City of Albuquerque

RE: DRAINAGE PLAN FOR SPARKLE ICE ADDITION (D17-D72)
ENGINEER'S STAMP DATED 2/2/95.

SUBJECT: Sparkle Ice Plant Permit- 3-13445

Subject: Sparkle Ice Addition - Storm Drain

GRADING & DRAINAGE PLAN

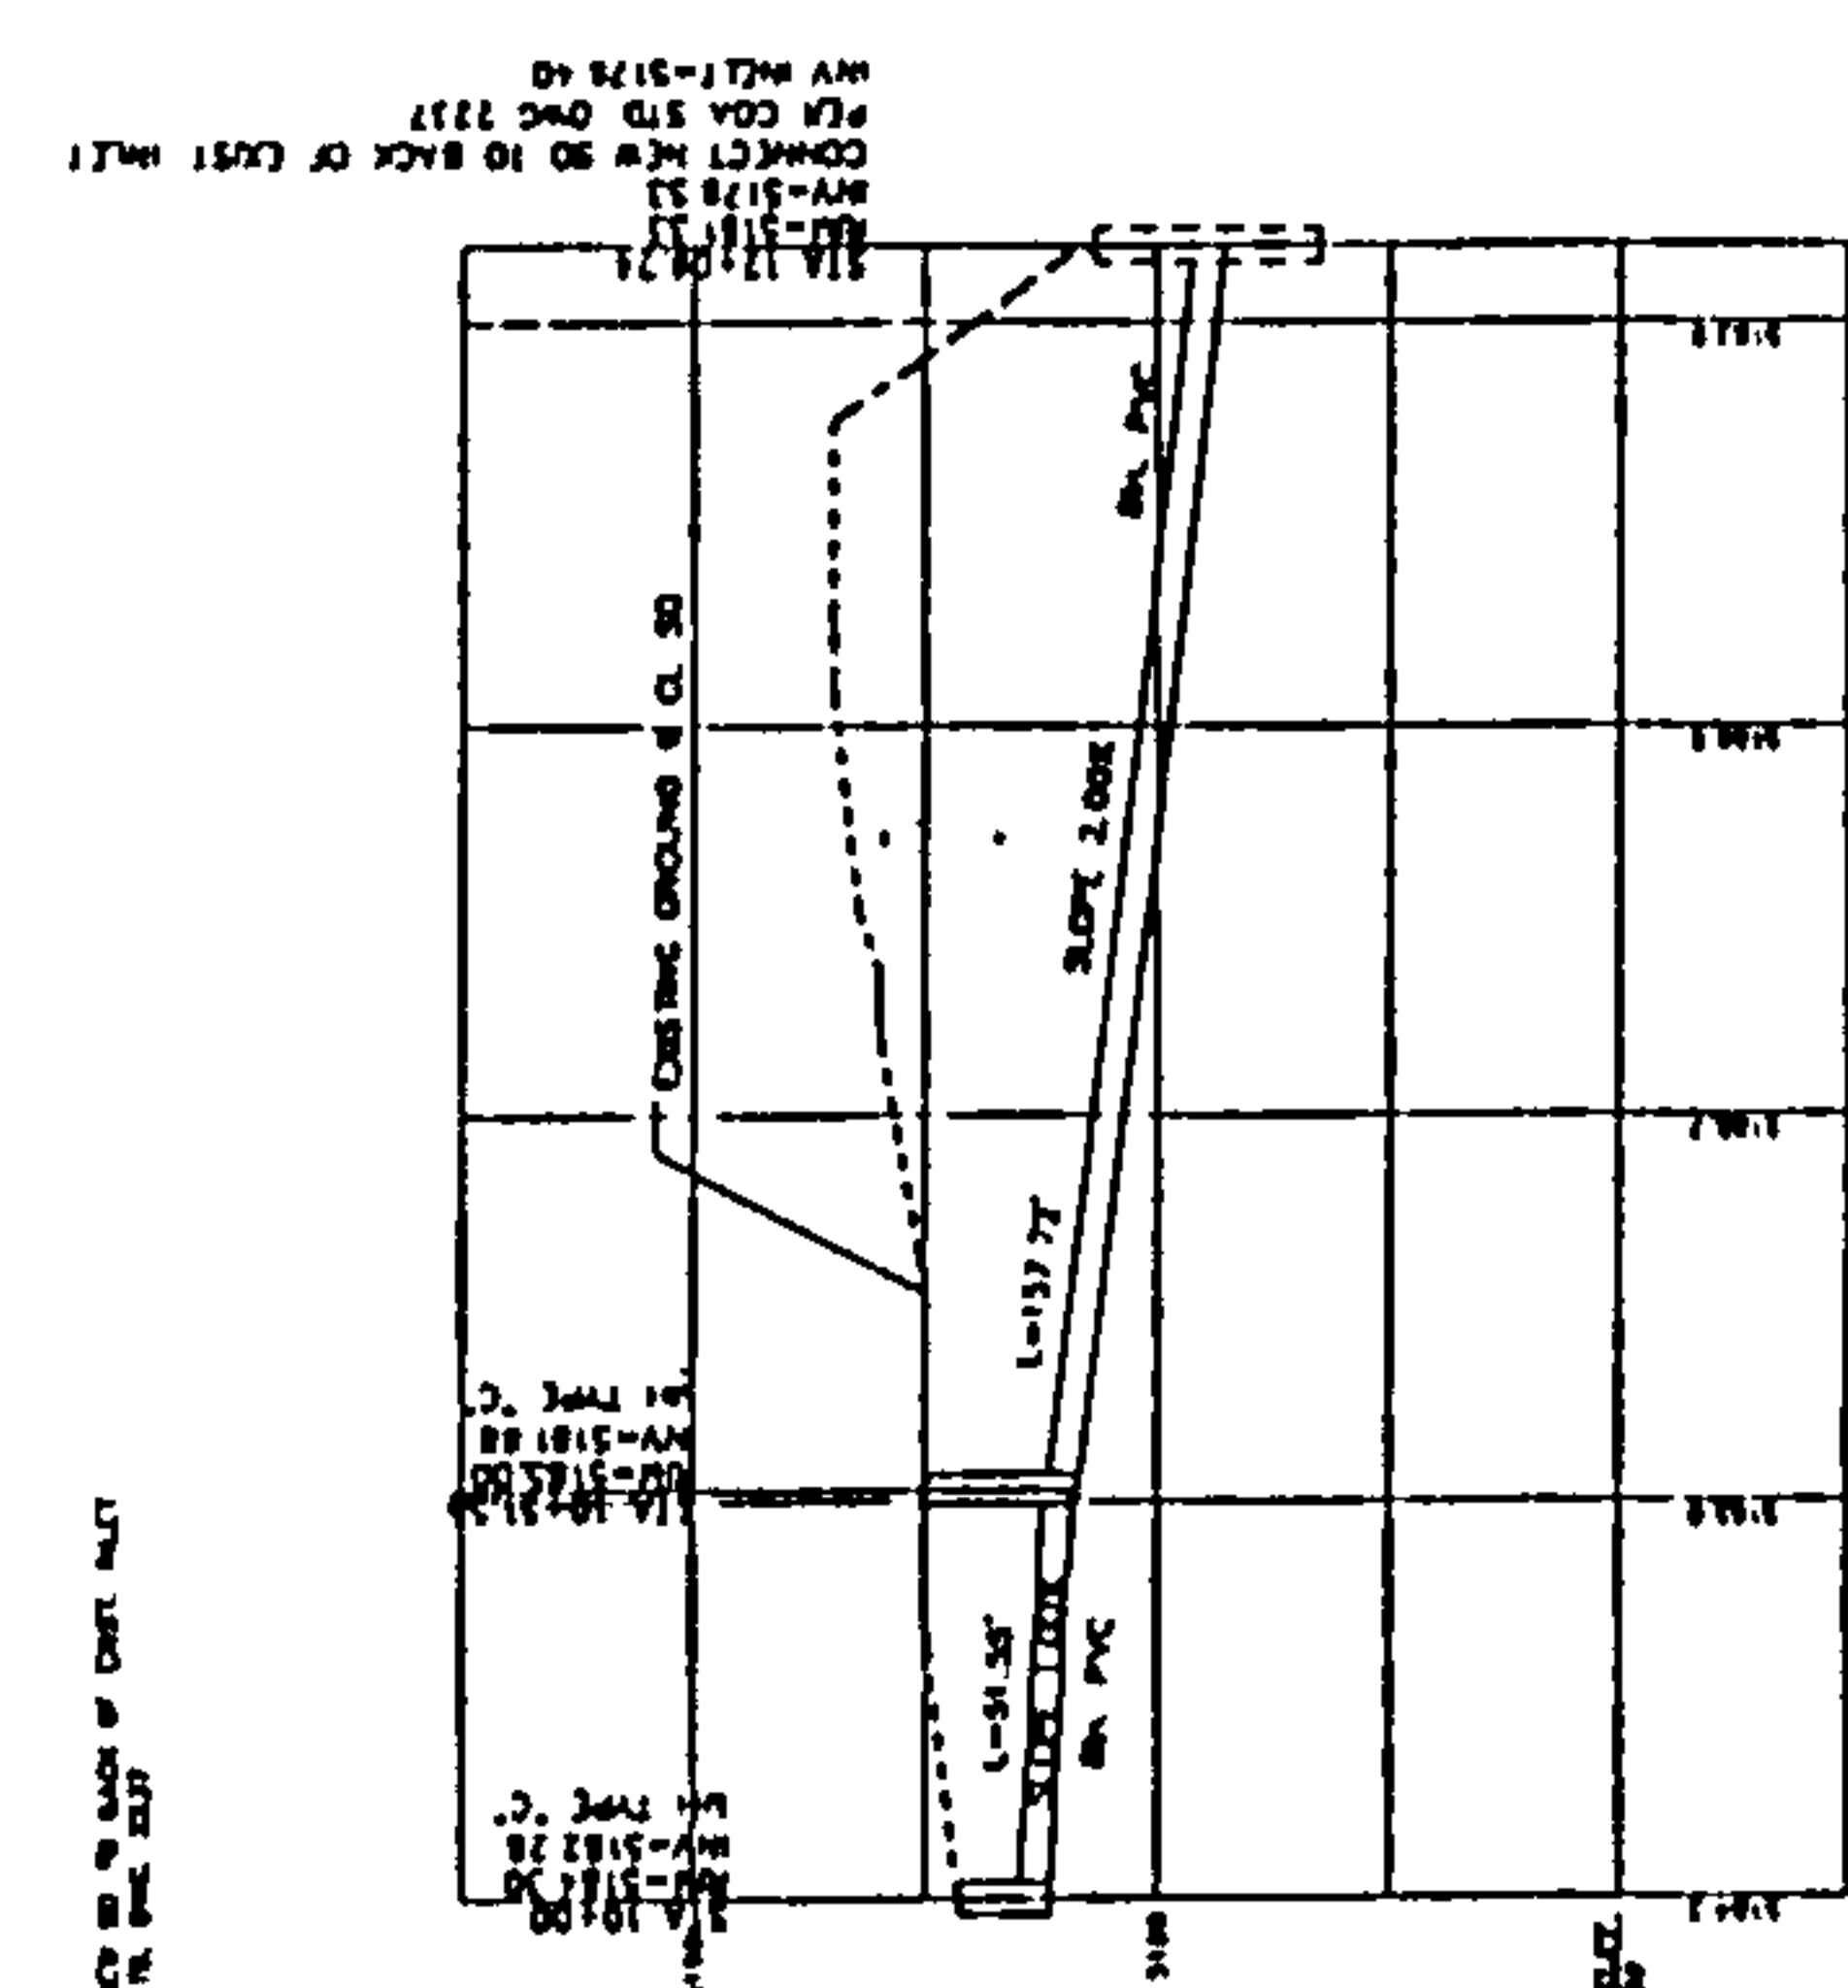
Please be advised that even though you have reduced the flow rate by the required landscaping, it is imperative that no damage occur to the downstream properties. If for some reason any erosion is to occur on the slope, a more defined depressed area on the west side of the property will need to be constructed.

Also, any further development within the property will require a Master Plan which will require discharge of developed run-off towards the frontage road.

I have reviewed the proposed storm drain project to be connected to the Highway Department's existing drop inlet, and found the connection to be acceptable.

Since, the expected additional discharge is minimal, there is no anticipated impact to the Department's storm drain system.

In addition, the report stated that the water quality has been tested from the ice making operation, and showed no contaminants were present to impact the water quality. Therefore, the Drainage Section approves the proposed connection.
